The Coal
Authority

Re: Application 2024/44/93598/W

Discharge of condition 11 (validation report) on previous permission 2020/90442 for variation condition 2 (plans) on previous permission 2016/92055 for erection of 109 dwellings with associated works; Land East of, Crosland Road, Lindley, Huddersfield, HD3 3SU, RECONSULTATION.

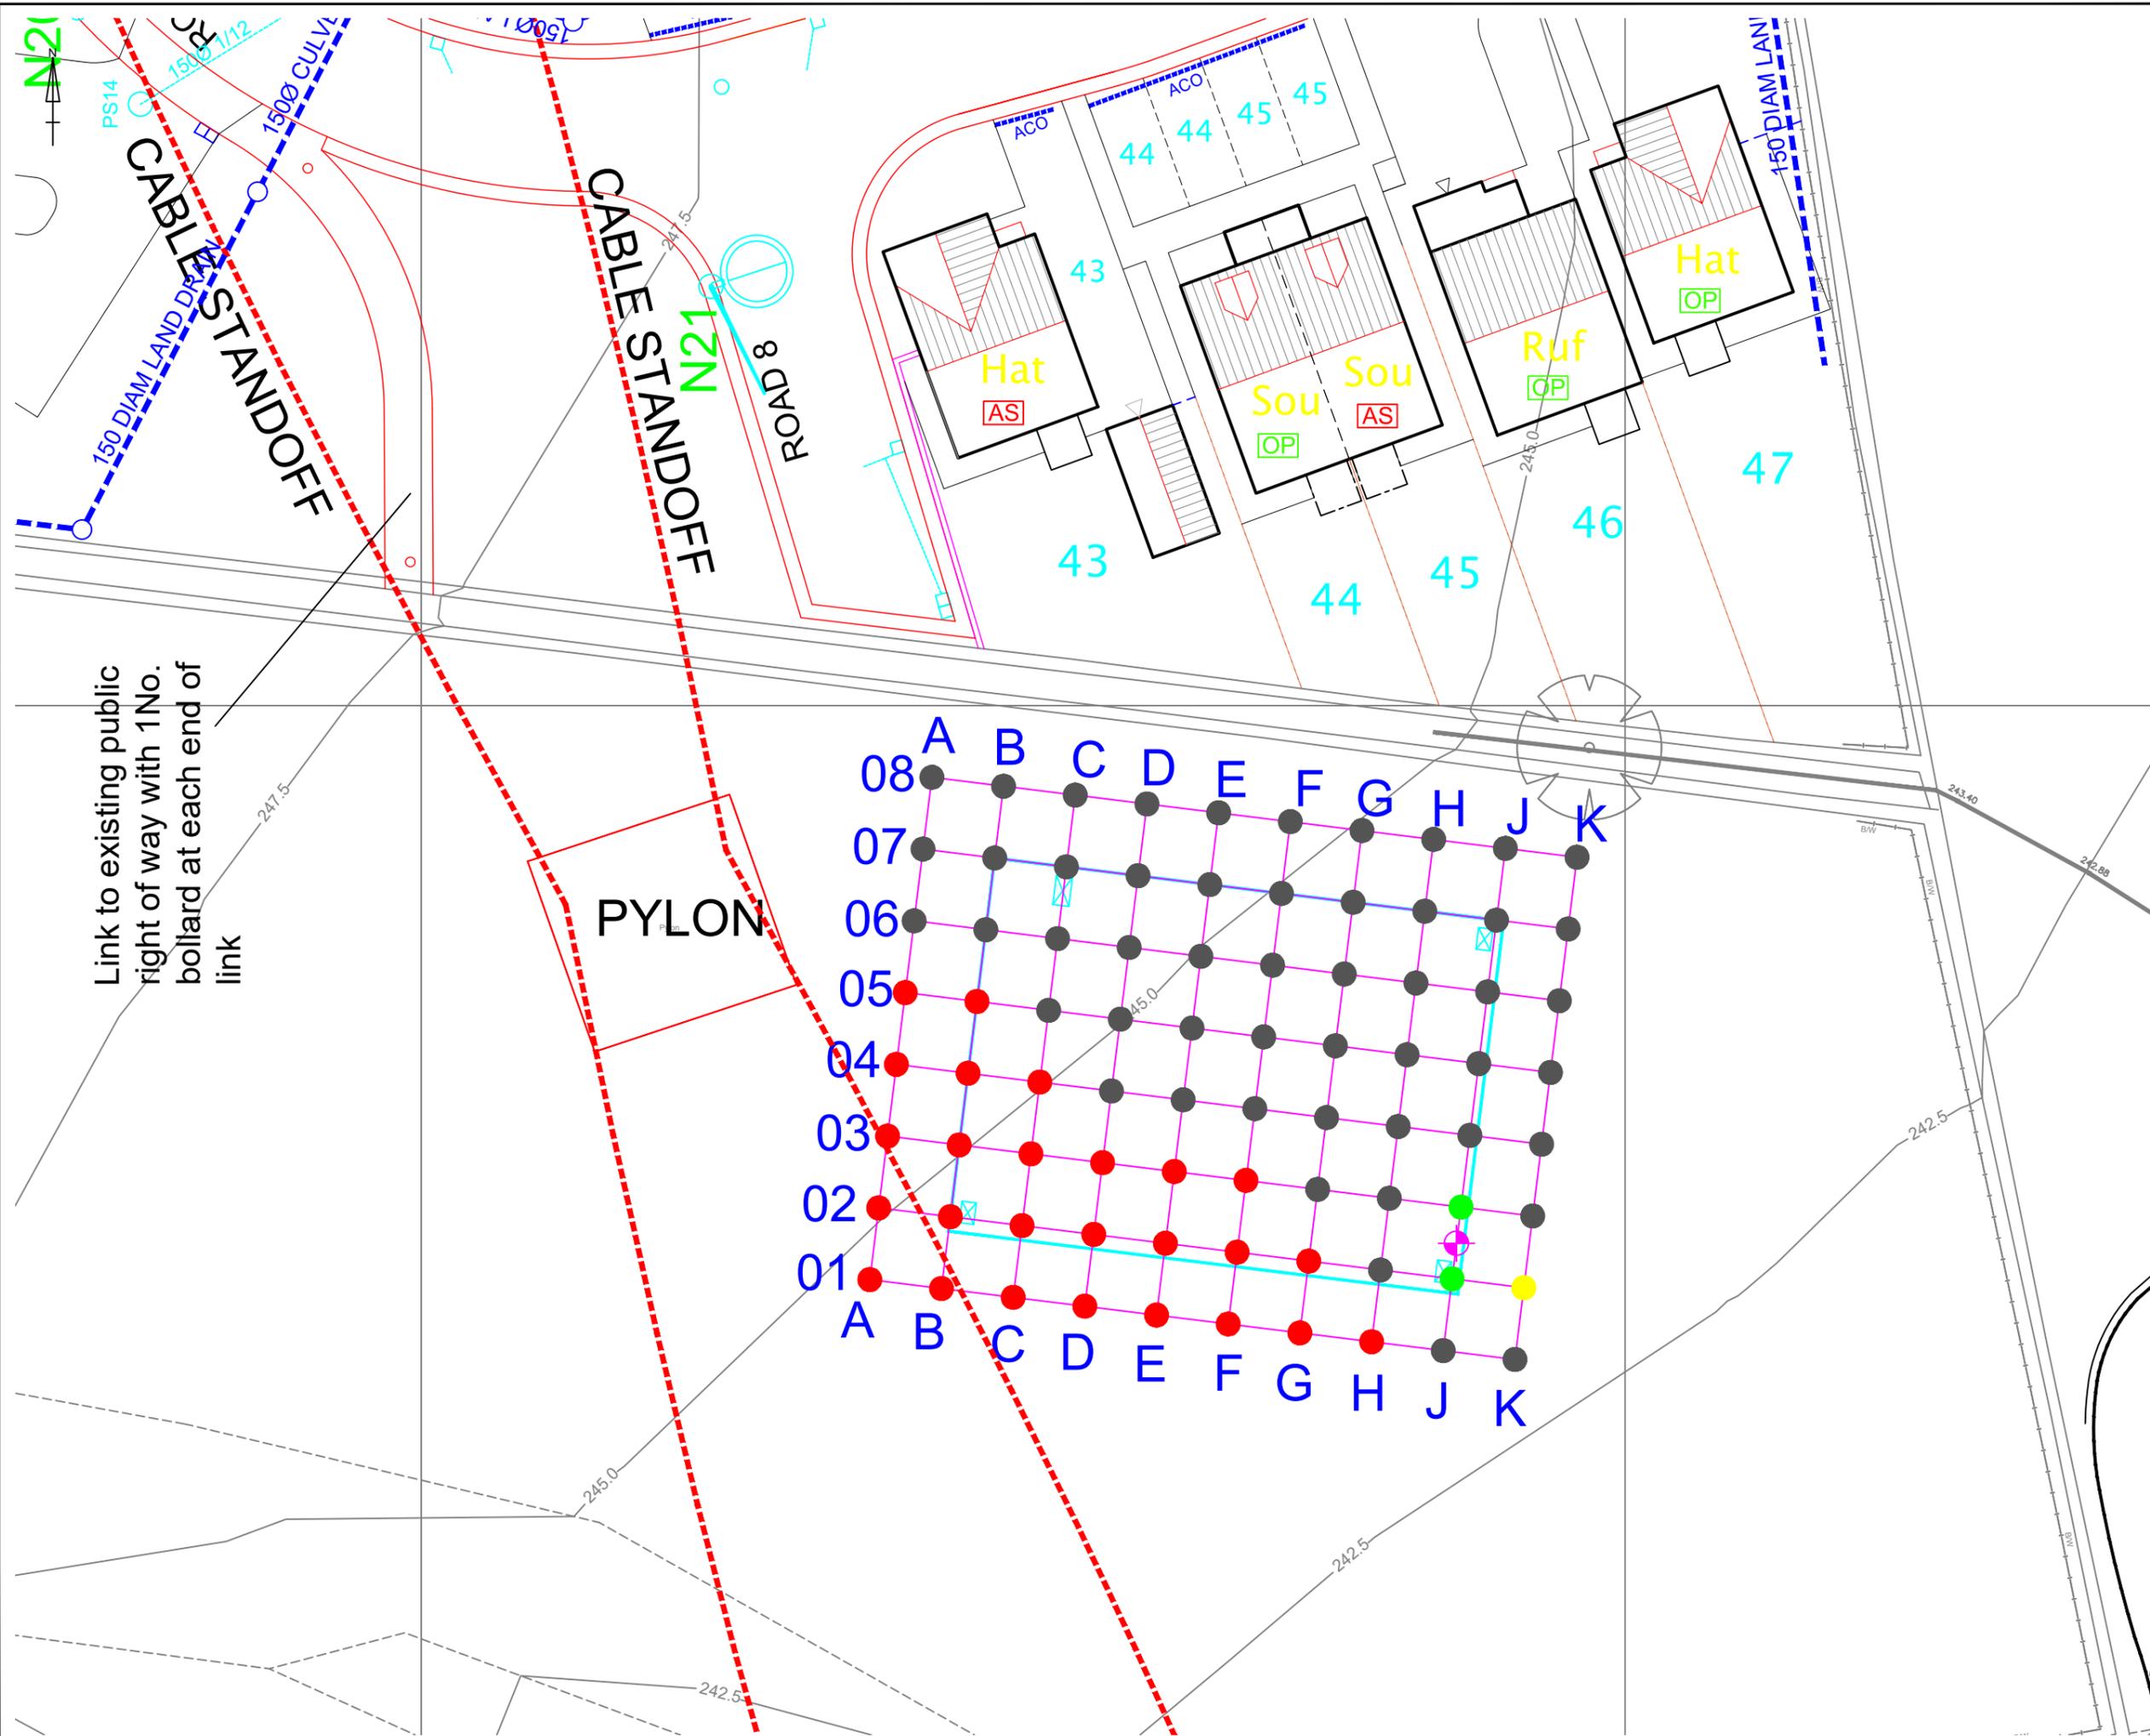
previously as the southern spur by Lithos Consulting. The grouting exercise found intact coal in the north of the treatment area closest to the Persimmon Homes residential area but does not appear to have defined either the location of the coal crop which might have been anticipated or the occurrence and position of a geological fault anticipated close to the treatment grids northern margin.

For clarity and the avoidance of doubt, and to demonstrate compliance with Condition 11, the applicant should be requested to provide a suitable verification statement from their technical consultant which specifically confirms that the agreed remediation strategy has been implemented in full and that the site has been made safe and stable for the proposed development in terms of coal mining legacy matters.
